CITY OF ALBUQUERQUE

PLANNING DEPARTMENT – Development Review Services

RE: **El Manzanal Subdivision** - 704 Griegos Road, NW
Conceptual Grading & Drainage Plan
Engineer's Stamp Date (none) (File: F14D069)

PRELIMINARY
GRADING AND
DRAINAGE PLAN

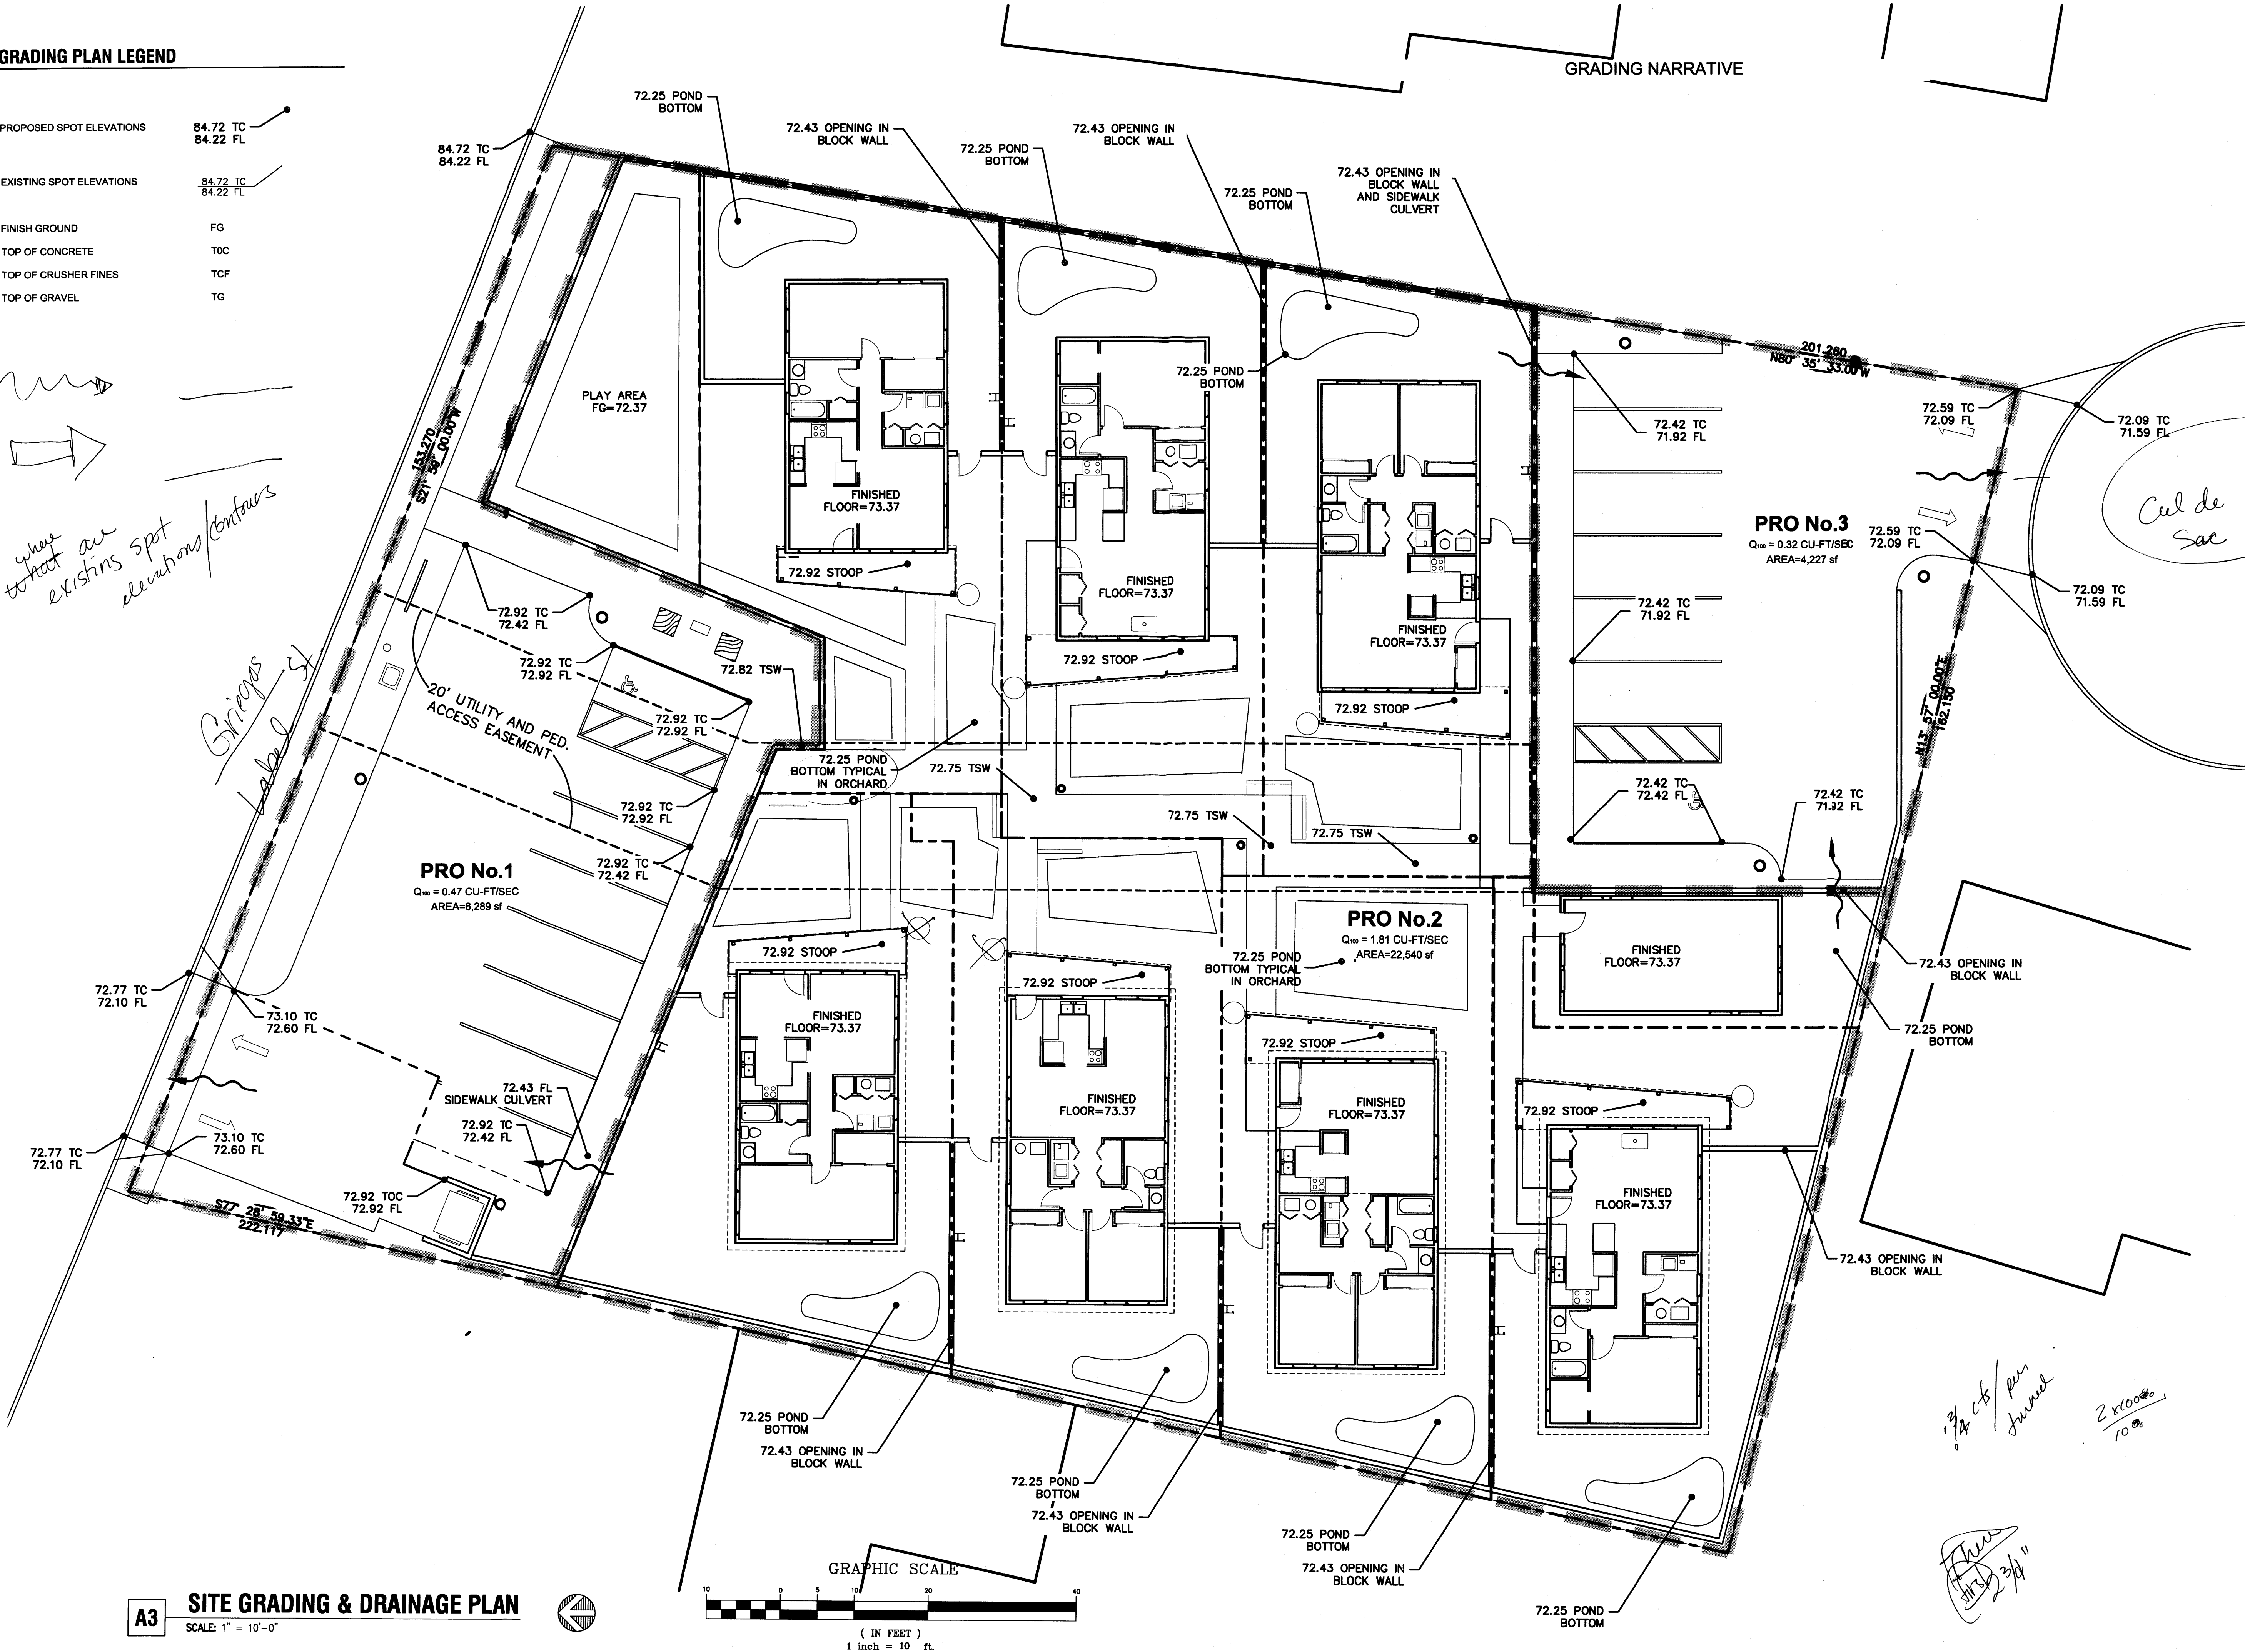
1. Show existing spot elevations/ contours on site and adjacent to property
2. State how the first flush is to be managed.
